**Consultation Response from KC,
Trees**

2025/90336 30A, Daisy Lea Lane, Lindley, Huddersfield, HD3 3LP

**Erection of single storey rear orangery and detached double garage with storage to the front
(within a Conservation Area)**

Date Responded: 25/02/2025

Drawing Title  
**Proposed Site Plan**

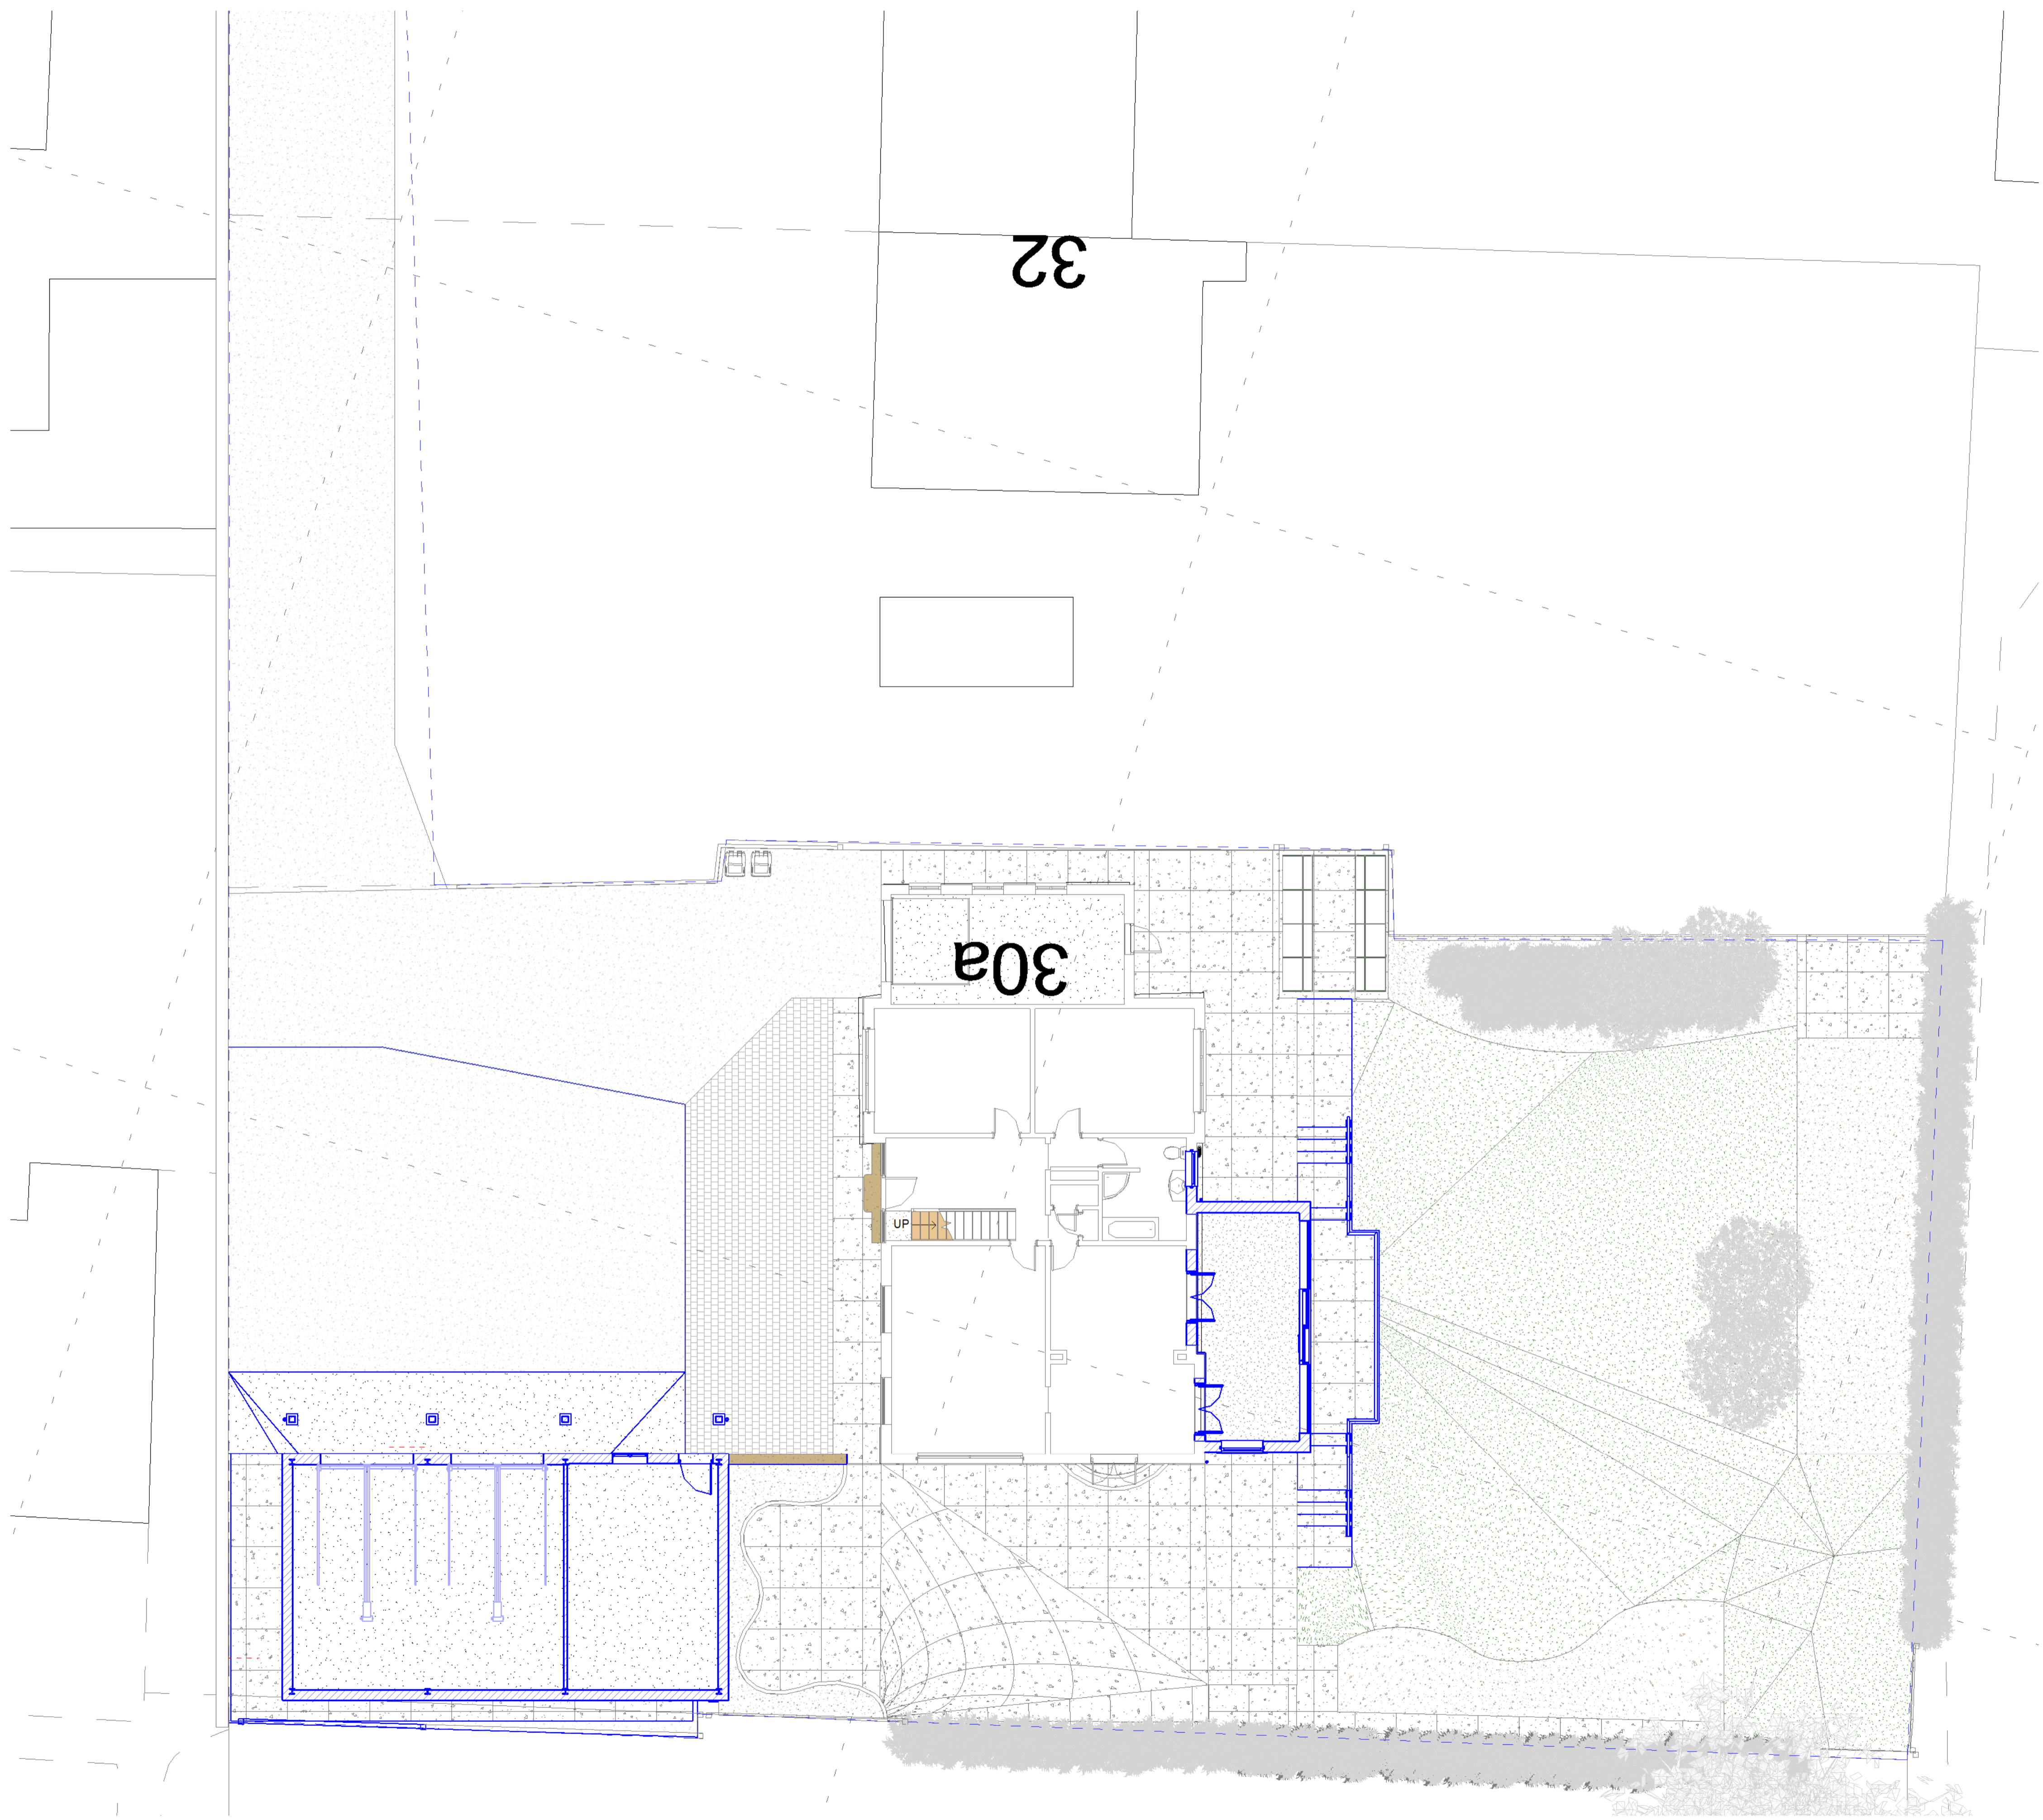
There has been no Arboricultural Impact Assessment (AIA) submitted which would be expected when building in close proximity to protected trees. An AIA is required to accurately judge the effect these proposals will have on the adjacent trees.

The proposals submitted for the garage appear to be within Root Protection Areas of at least four trees, potentially 5. This would at the very least have an extremely negative impact on the trees survival and at worst kill all the surrounding trees.

It also looks like the trees would require significant pruning in order to fit the garage in that location which again would not be acceptable.

The most logical location in my opinion would be to have the garage adjoining the property on the south aspect where there are no trees.

There is an objection to the submitted plans as they directly conflict with adopted Kirklees local plan policies 33 and 24(i).
